E-MEMO				
	Name	Company		Email Address
To	James Catchpole	Built		JamesCatchpole@built.com.au
From	Aaron Celarc	Date	27 July 2020	Ref 77919-02BCA
Re	ICS Revised Scope BCA Compliance Memo

As Registered Certifiers we have reviewed the 100% SSDA architectural design documents prepared by Woods Bagot (Appendix 1) for compliance with the current building assessment provisions, i.e. the Building Code of Australia 2019 Amendment 1 (BCA).

Figure 325 Extract of proposed plans – demolition plan level 32

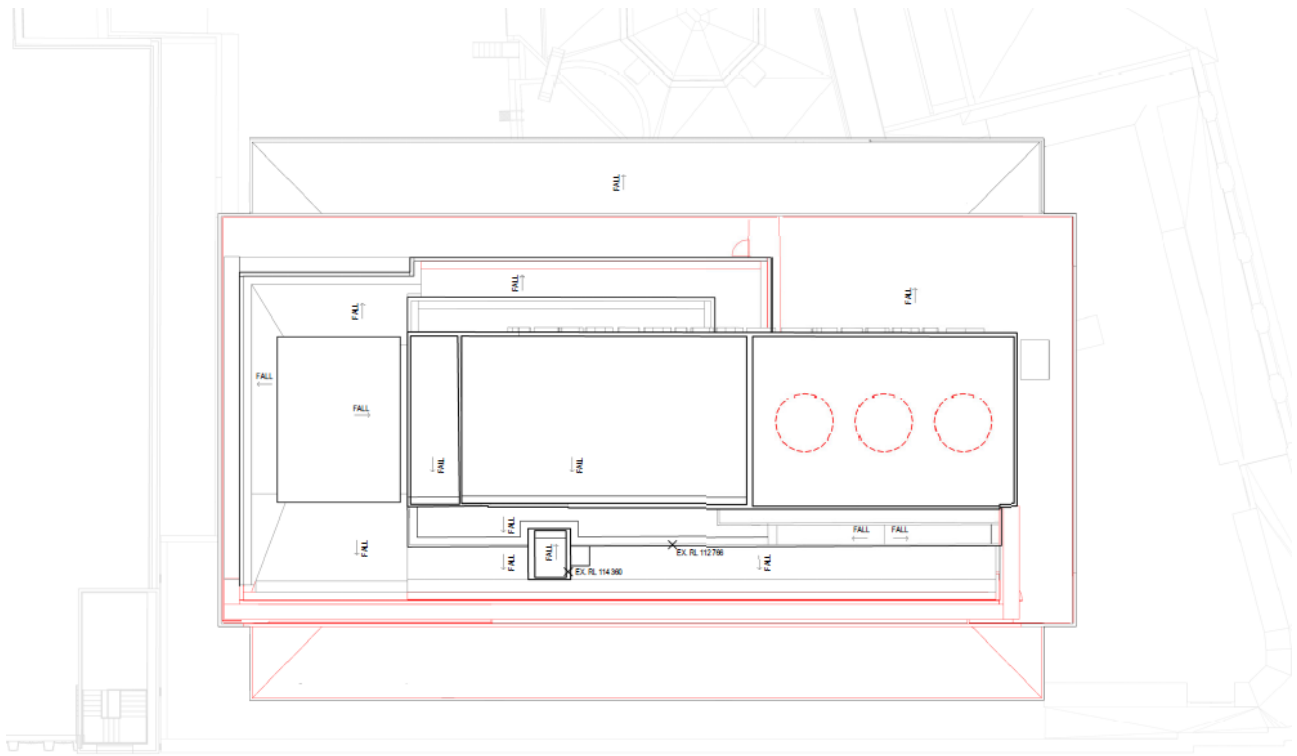
It is noted the level 32 rooftop bar/ dining area has an existing egress issue being that a single fire isolated stair is provided in lieu of two. This is to be taken into consideration by the Fire Engineer and a fire safety strategy proposed.

It is noted that the existing level 32 roof structure has been identified to have existing aluminium composite panels installed, which are likely non-compliant. It is recommended these be replaced to comply with current code.

Figure 329 Extract of proposed plans – internal cortile elevation showing proposed BCA compliant handrail to stair

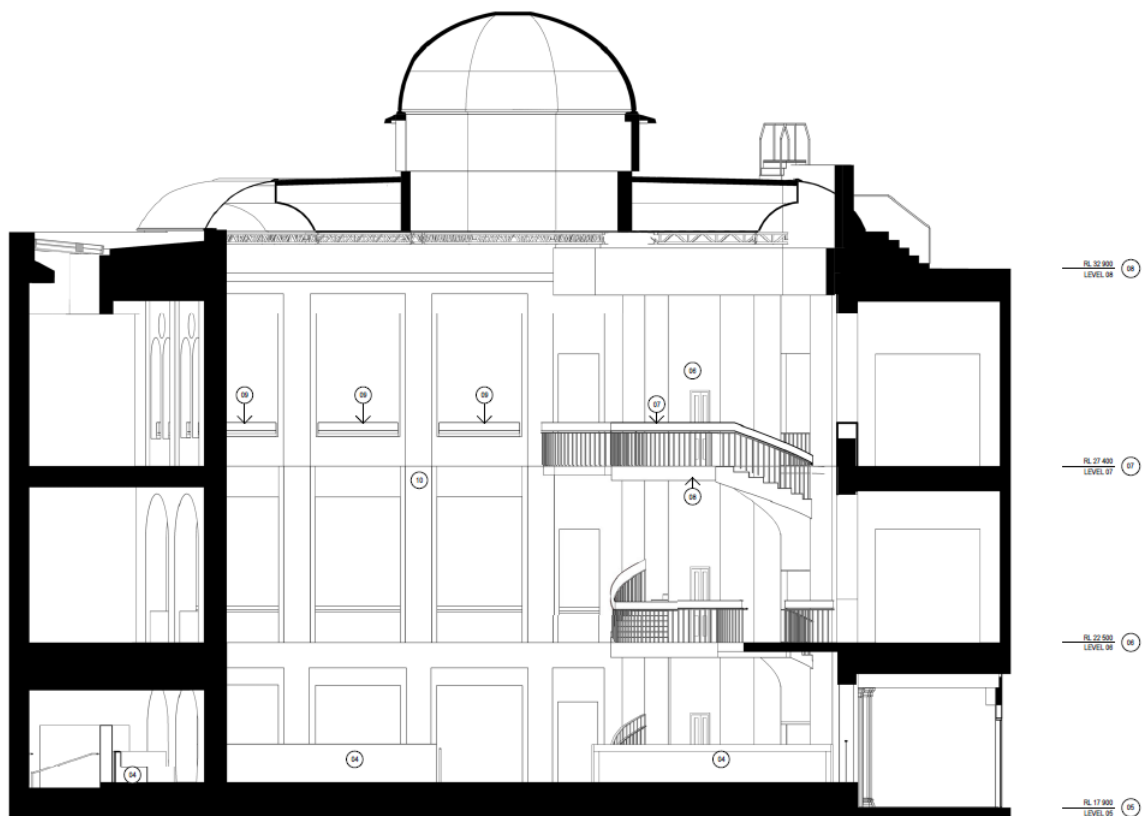
It is noted that the cortile stair balustrades and existing balcony barriers on level 7 are proposed to be upgraded in order to achieve compliance with the above
